Current Zoning: NC (neighborhood center)  
Proposed Zoning: MUDD-O PED (mixed-use development, optional, pedestrian overlay)

Approximately 1.62 acres located on the east side of East Morehead Street, south of South McDowell Street, and west of Baxter Street.

The petition proposes a non-residential mixed-use development on a parcel that currently has numerous retail uses.

SITE PLAN

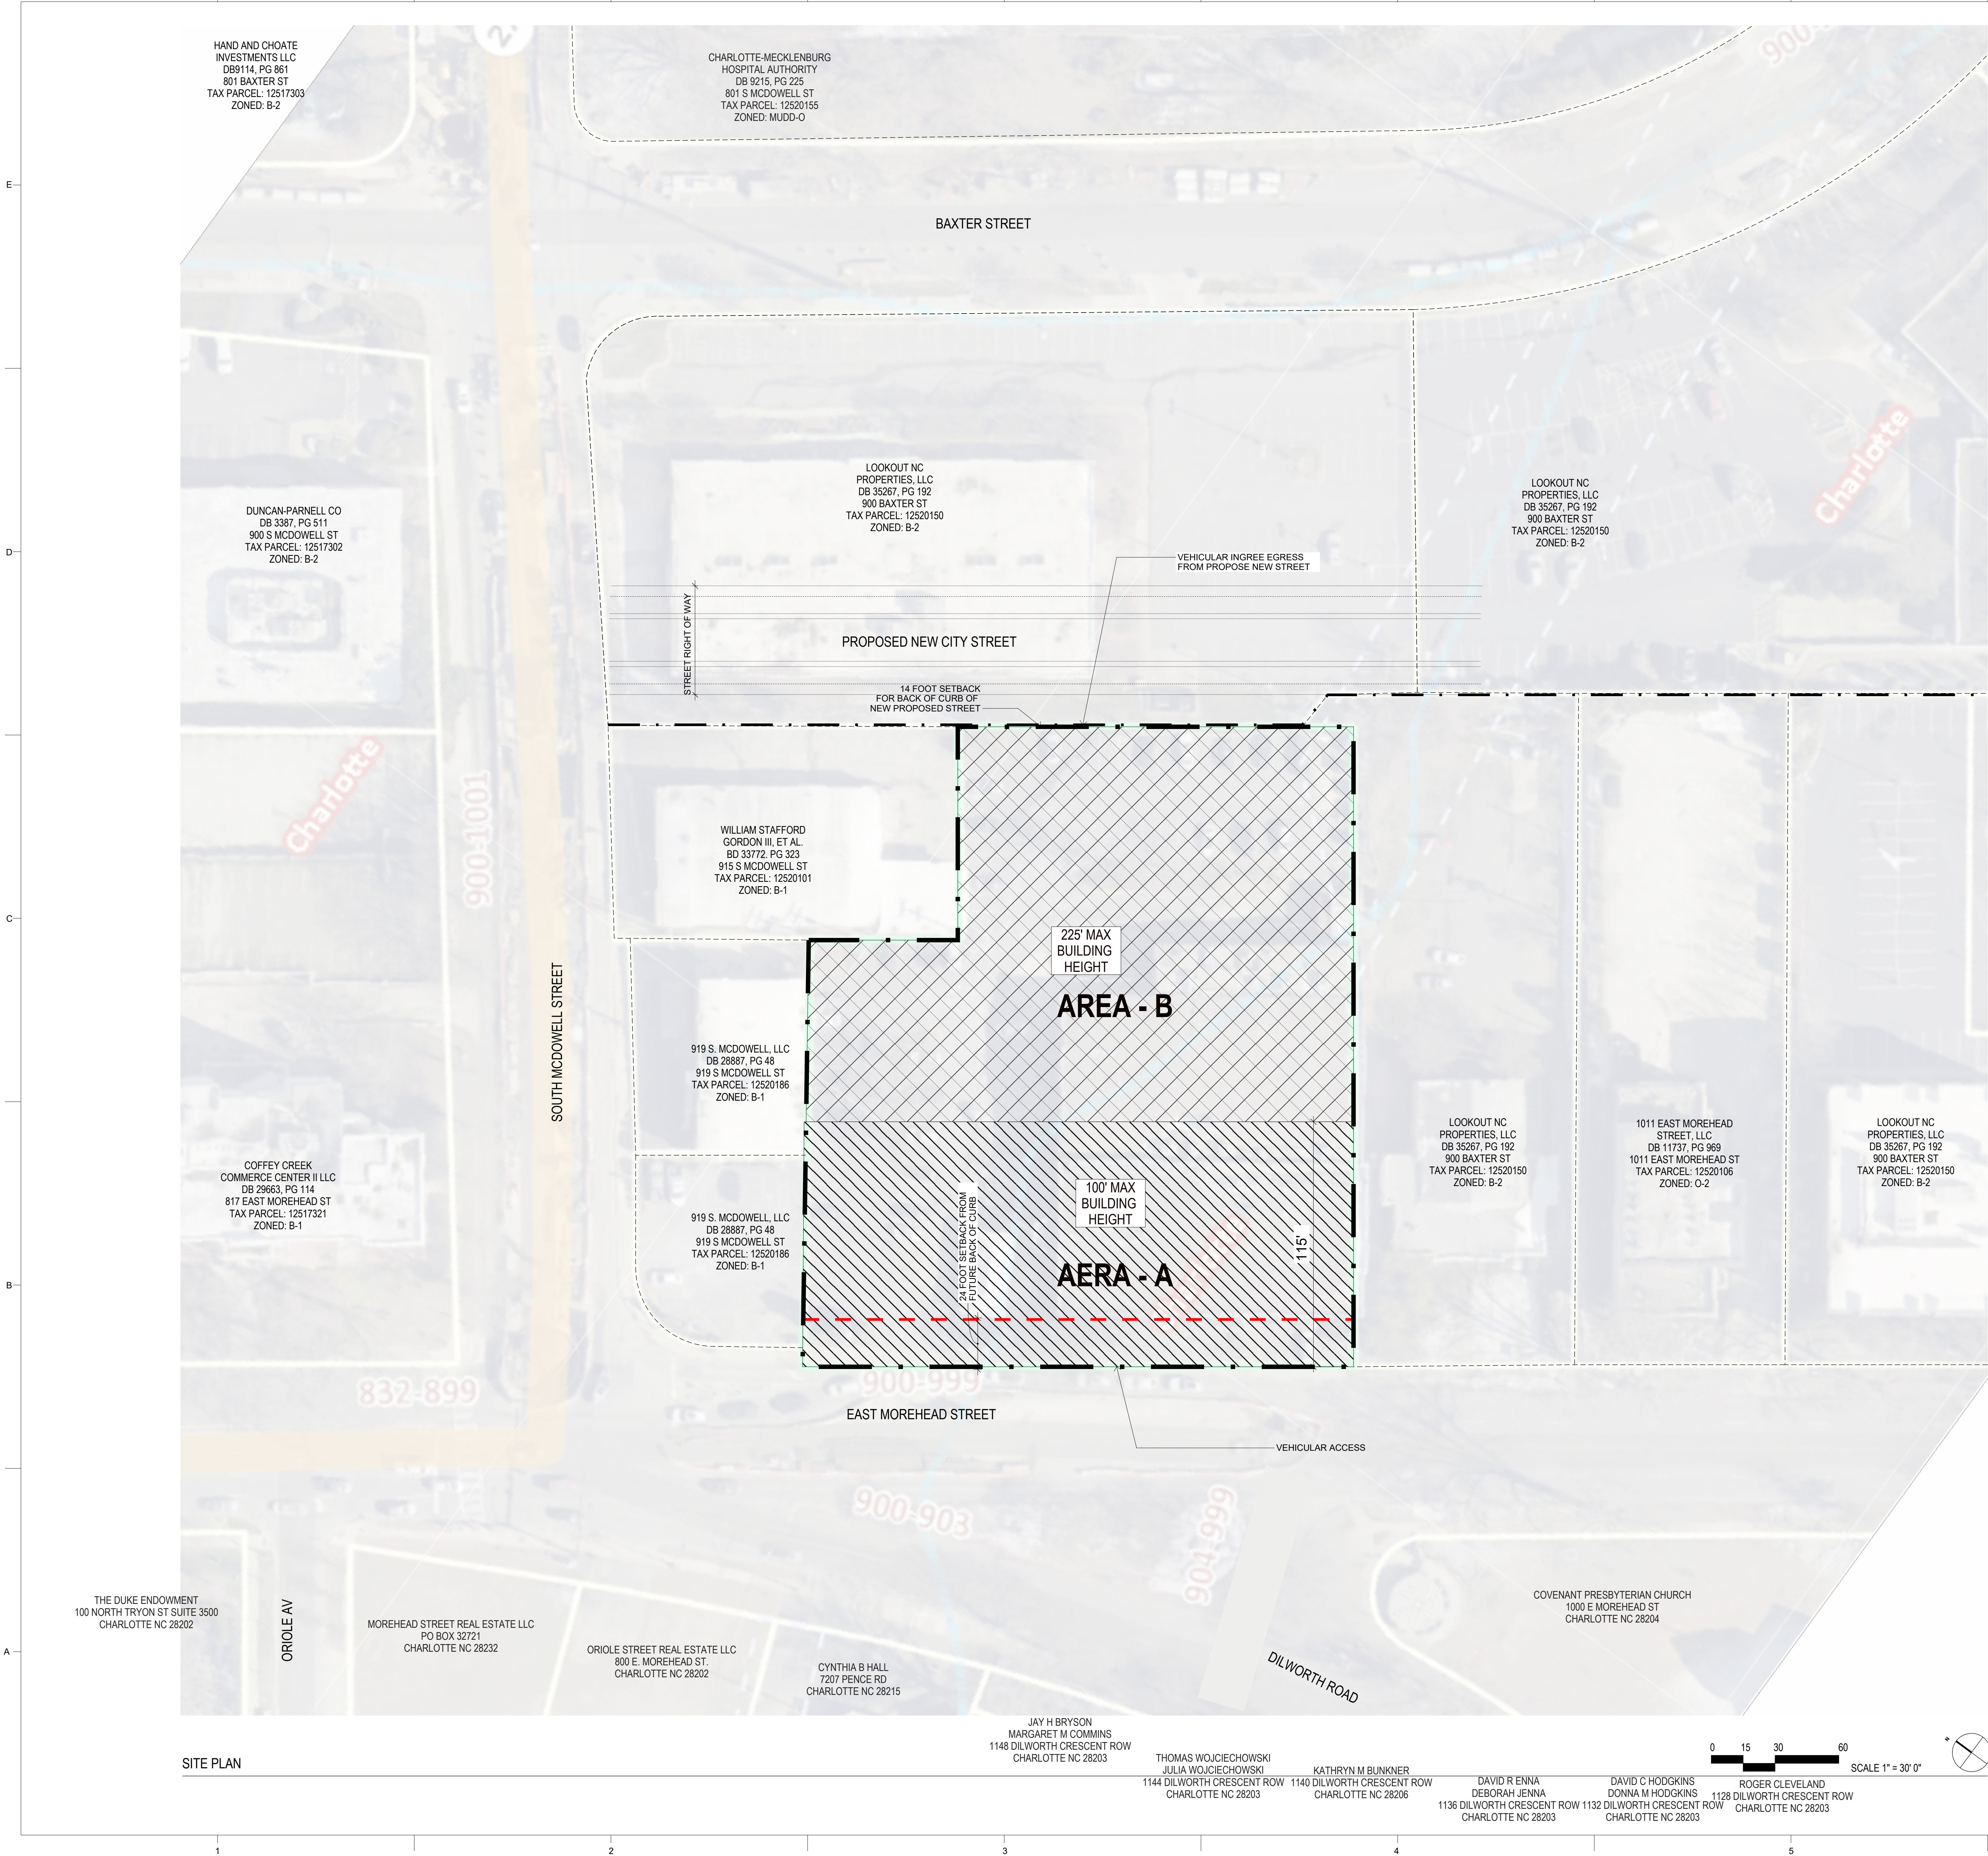
1. Please provide additional notes on proposed public benefits that would justify the maximum height of 225'.
